Your Ref: SSD-10410

**Development Application SSD-10410: Maroota Friable Sandstone Extraction Project**

RE: DA SSD-10410 - Maroota Friable Sandstone  
Extraction Project – BDAR review on SAI

CONCEPT PLAN OF PROPOSED UPGRADE WORKS AT WISEMANS FERRY RD AND PATRICIA FAY DR

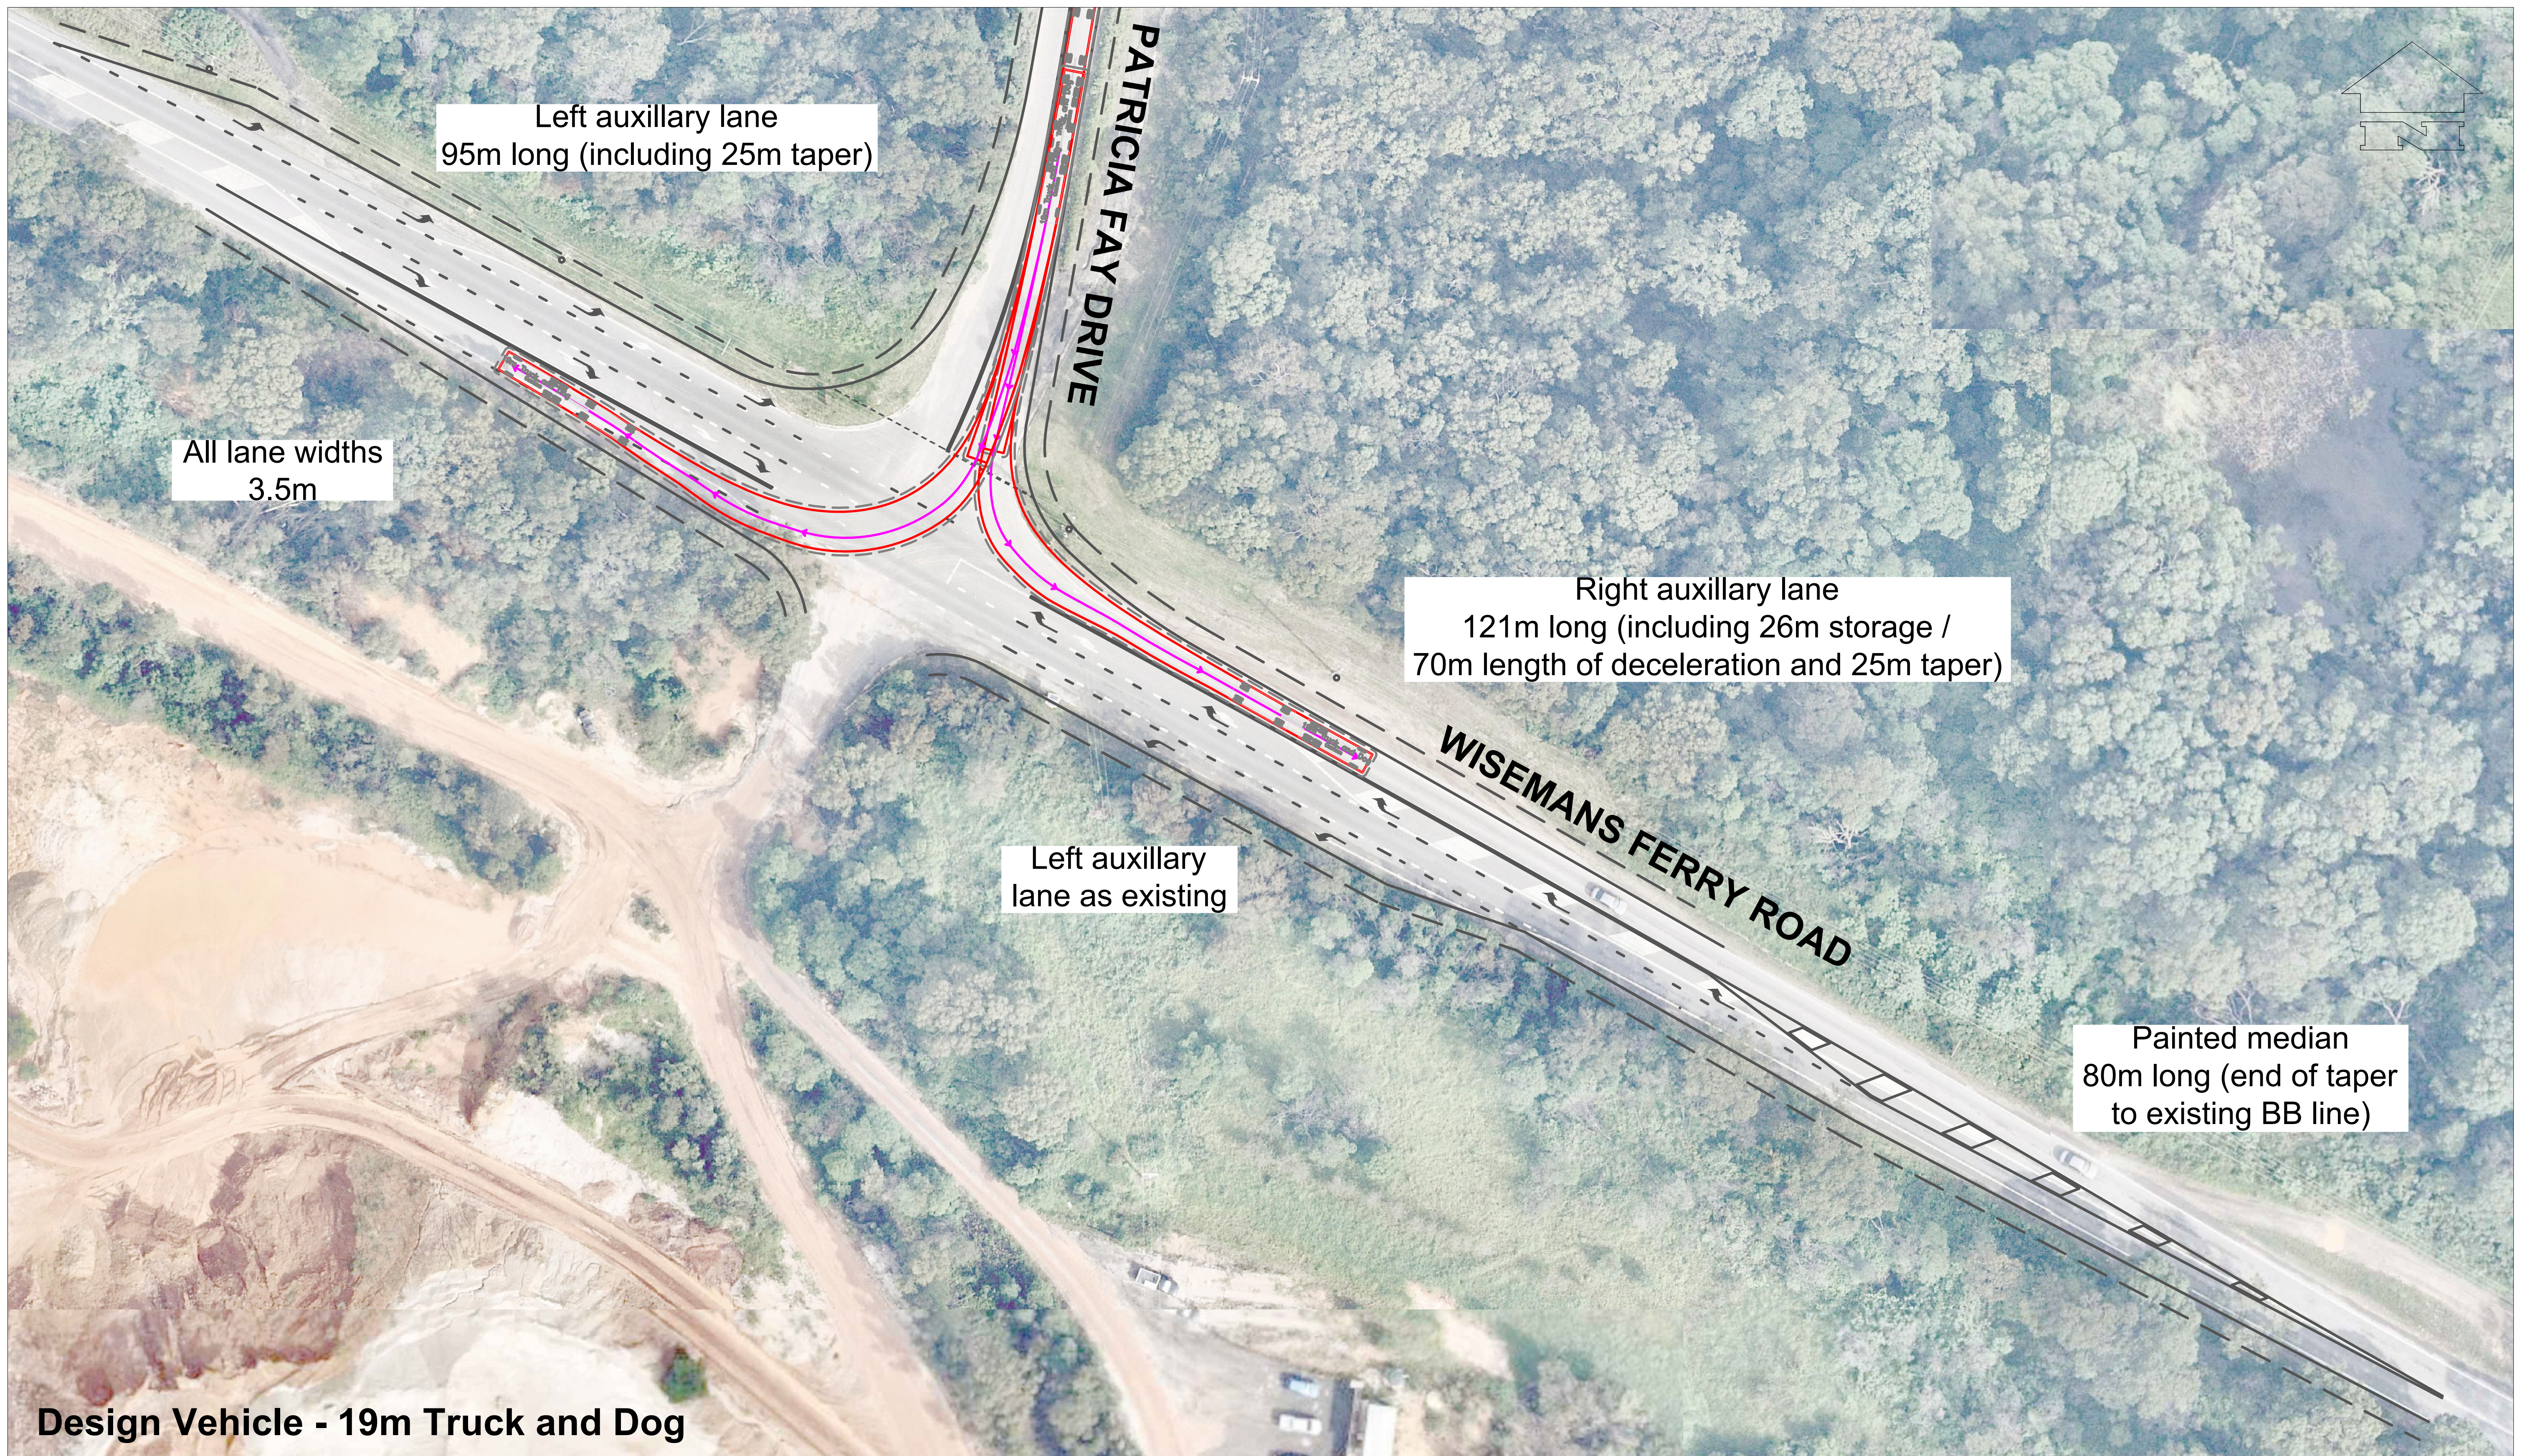
4. The application proposes to obtain access to the site only from Patricia Fay Drive.
5. Running alongside Patricia Fay Drive are 3 pipelines operated by P.F. That pipeline which carry sand, tailings and water to P.F.'s property on the opposite side of Wisemans Ferry Road. Without the pipeline, P.F. cannot operate and supply washed constructions sands throughout Sydney.

6. The EIS states that the proponent will need to construct a crossing over the pipeline: p 46.
7. No plans are provided indicating what this will entail. The proponent intends to delay providing plans until the construction certificate stage: EIS, p 46.

10. Without plans of the crossing, or any detail of what works are required, the consent authority cannot assess:
  - a. whether clearing is required;
  - b. any impacts on biodiversity values;

- c. the safety of use of the crossing;
  - d. any visual impact;
  - e. impacts on the pipelines; and
  - f. any other engineering and construction impacts.

11. The appropriateness of the only proposed means of entry to the development cannot be assessed.
